From: Planning
Subject: FW: FAO: Ben Taylor - Grindleton Parish Council consultation feedback 3/2025/0830 Greenbanks Farm, Green Lane, Grindleton BB7 4QJ

From: grindletonpc <grindletonparishcouncil@gmail.com>
Sent: 31 March 2026 10:06
To: Planning <planning@ribblevalley.gov.uk>
Cc:
Subject: FAO: Ben Taylor - Grindleton Parish Council consultation feedback 3/2025/0830 Greenbanks Farm, Green Lane, Grindleton BB7 4QJ

The parish council wishes to record their objection to this application in its current form.

**Pre-Development Plan
Baseline Map**

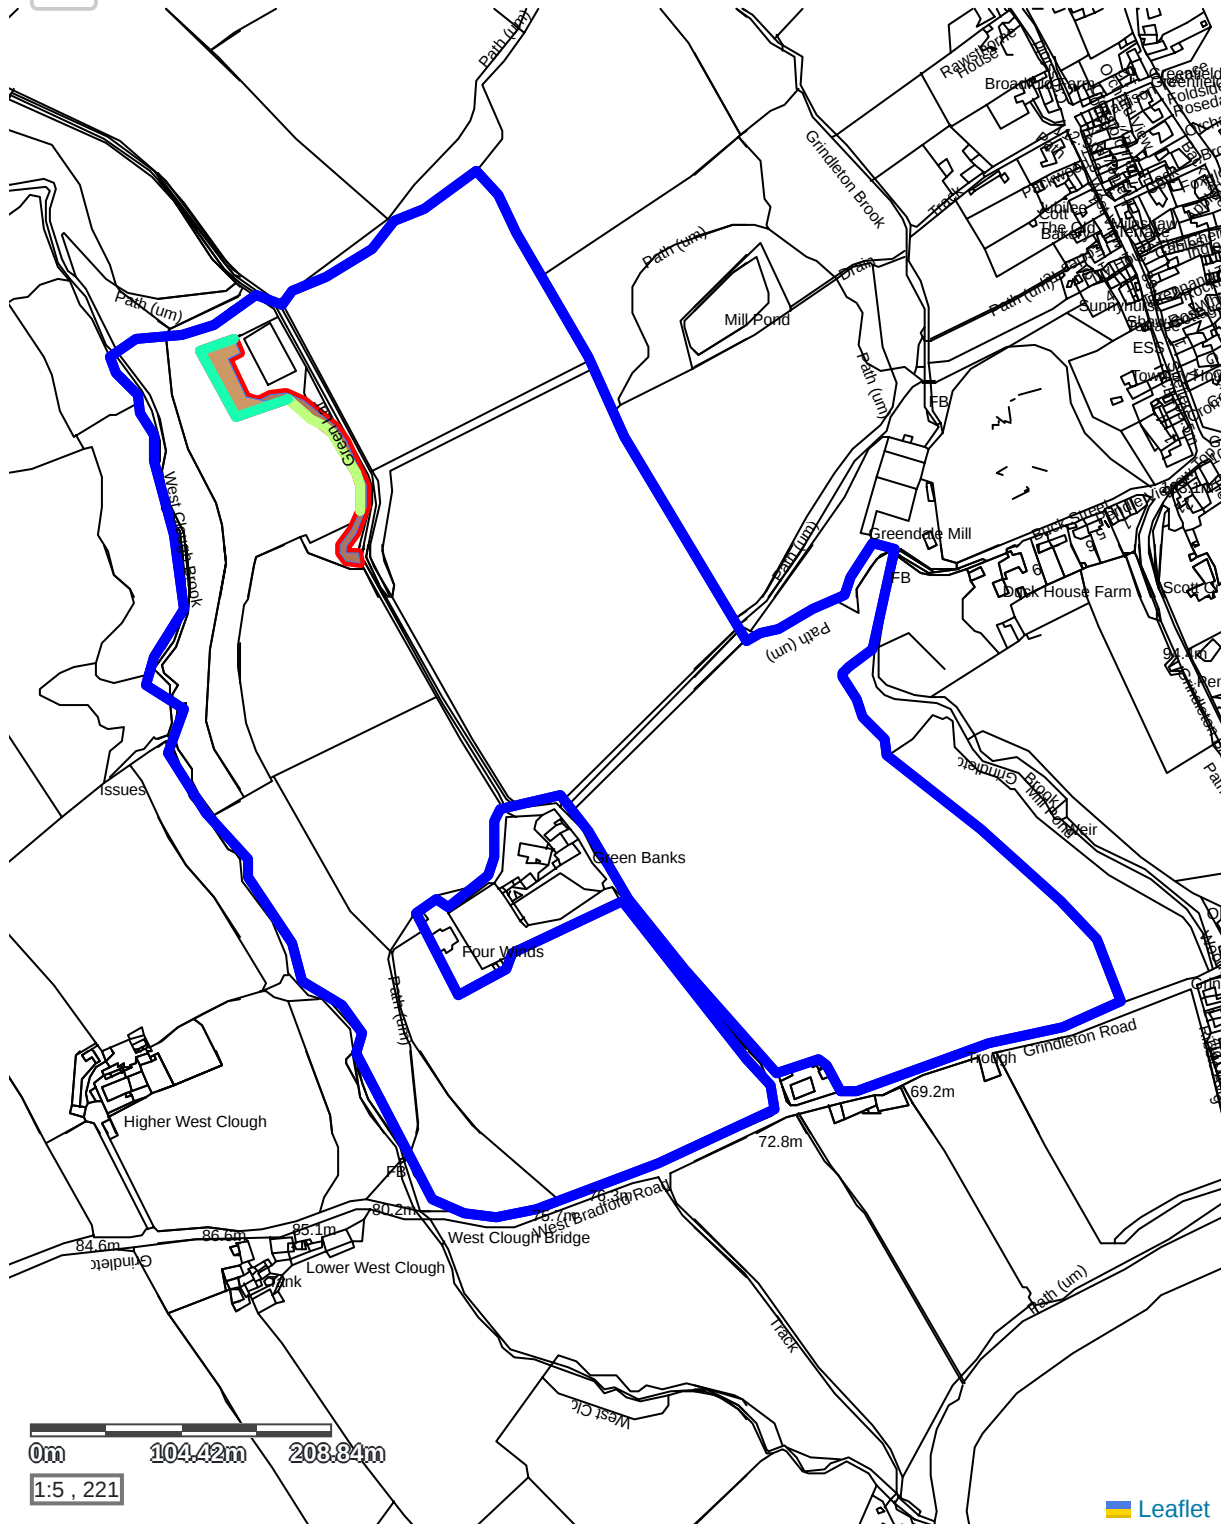
- The Biodiversity Net Gain (BNG) proposal as it stands does not satisfy, It appears what is being suggested is that an improvement in biodiversity is achieved by 'offsetting' through tree planting on a different site, this information is vague and confusing. There is no detail on tree species, number of trees etc. The Parish Council urges the district council to ensure their local surveyors and developers are taking the BNG legislation seriously, particularly as the site is within a Natural Landscapes area.

Planning Application
 Proposed Elevations

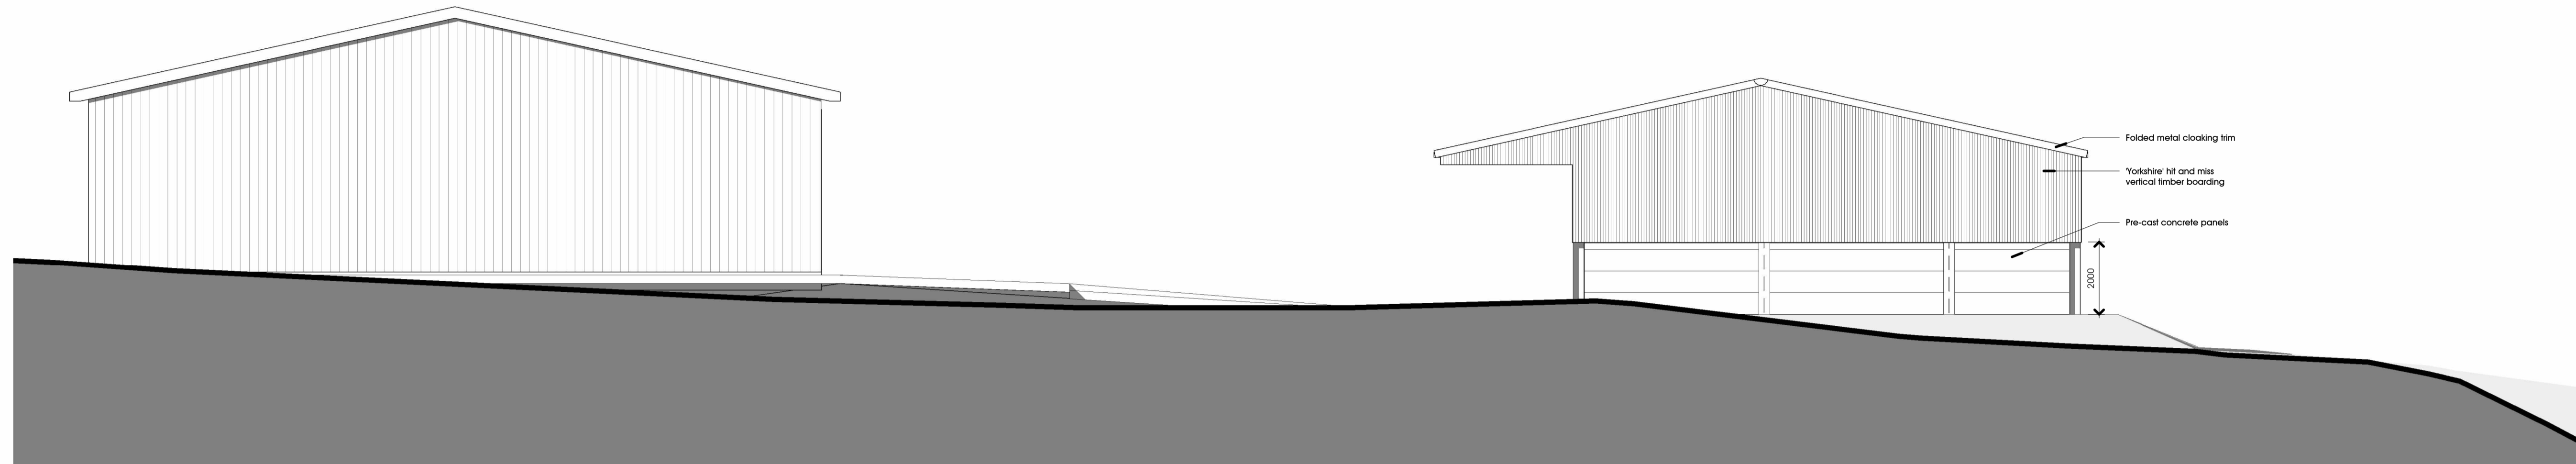
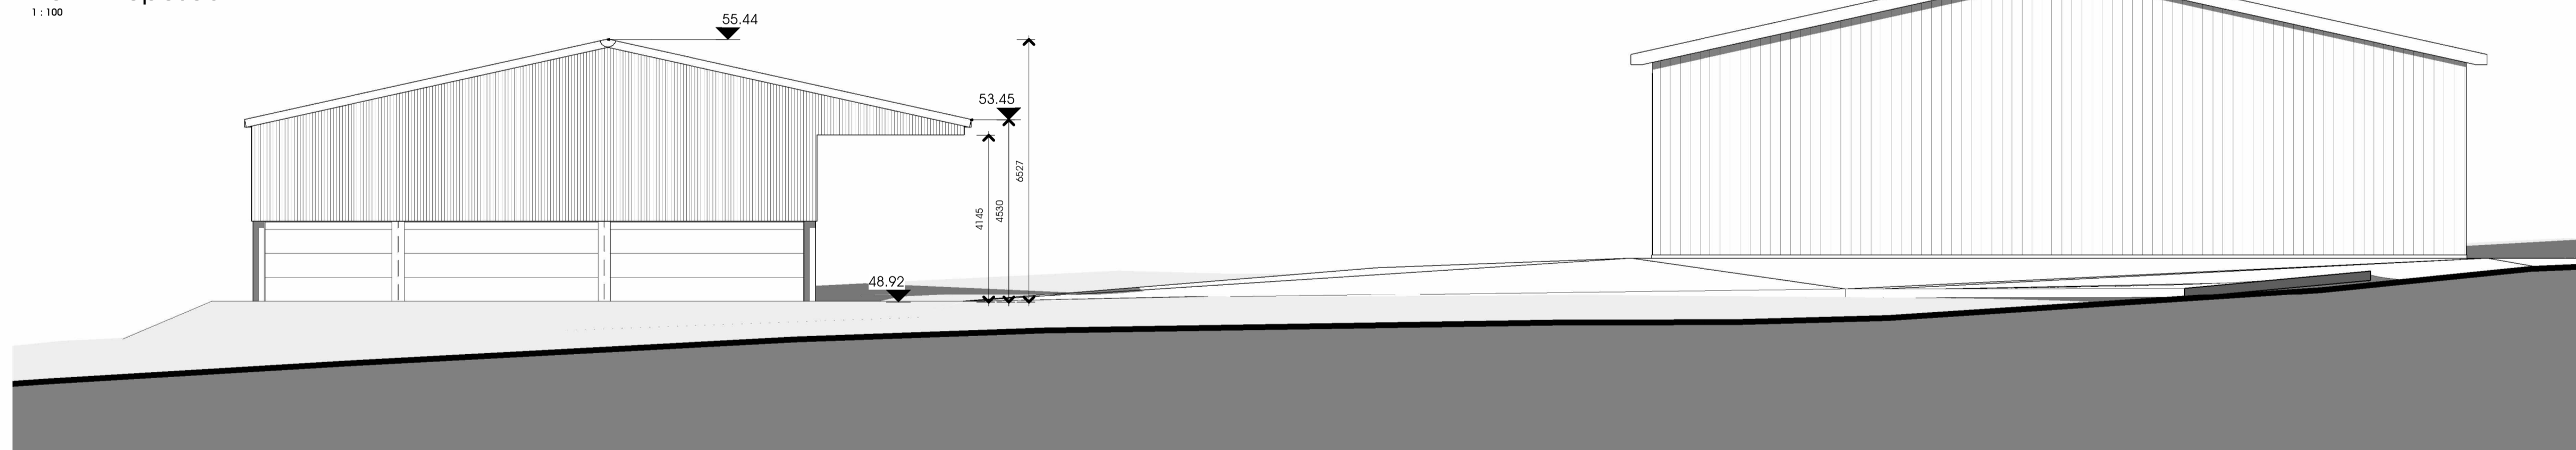
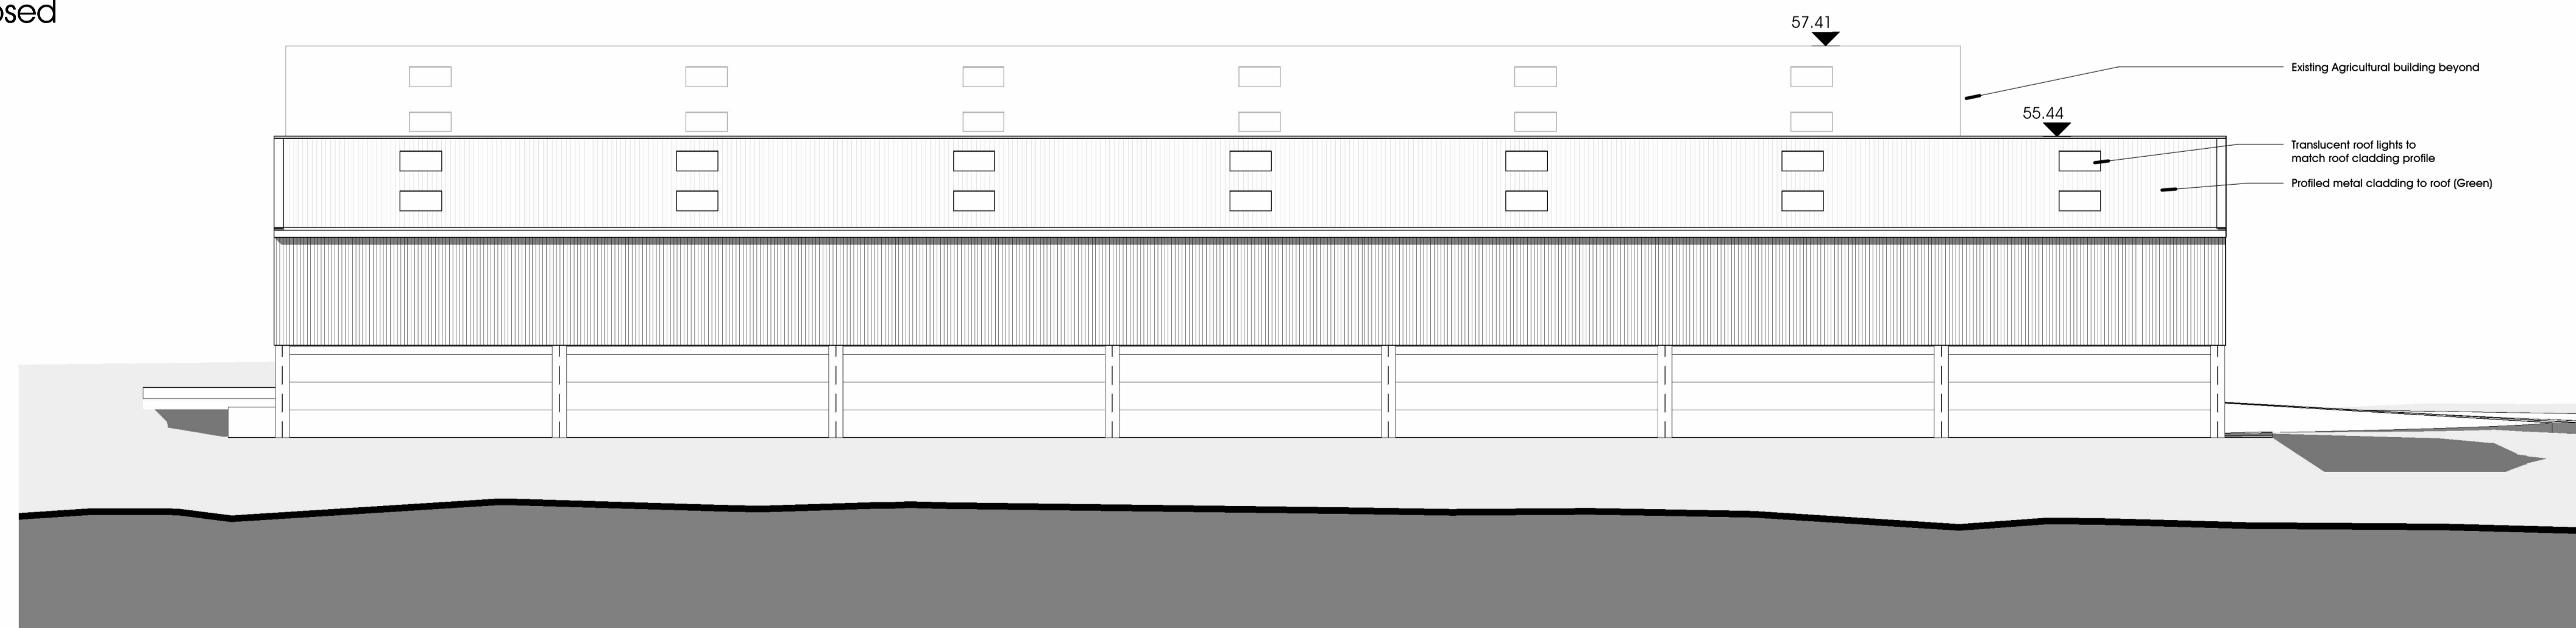
- The parish council observe that following a previous planning approved planning application approximately seven years ago a building was erected on this site directly in line of a protected view from Main Street, the impact of this was made worse by the removal of a number of very large trees, the addition of another building will affect the protected view further.

- The proposed new building site will need significant levelling and in-filling, this will come close to the edge of the valley, this application may therefore have an effect on the surrounding environment.
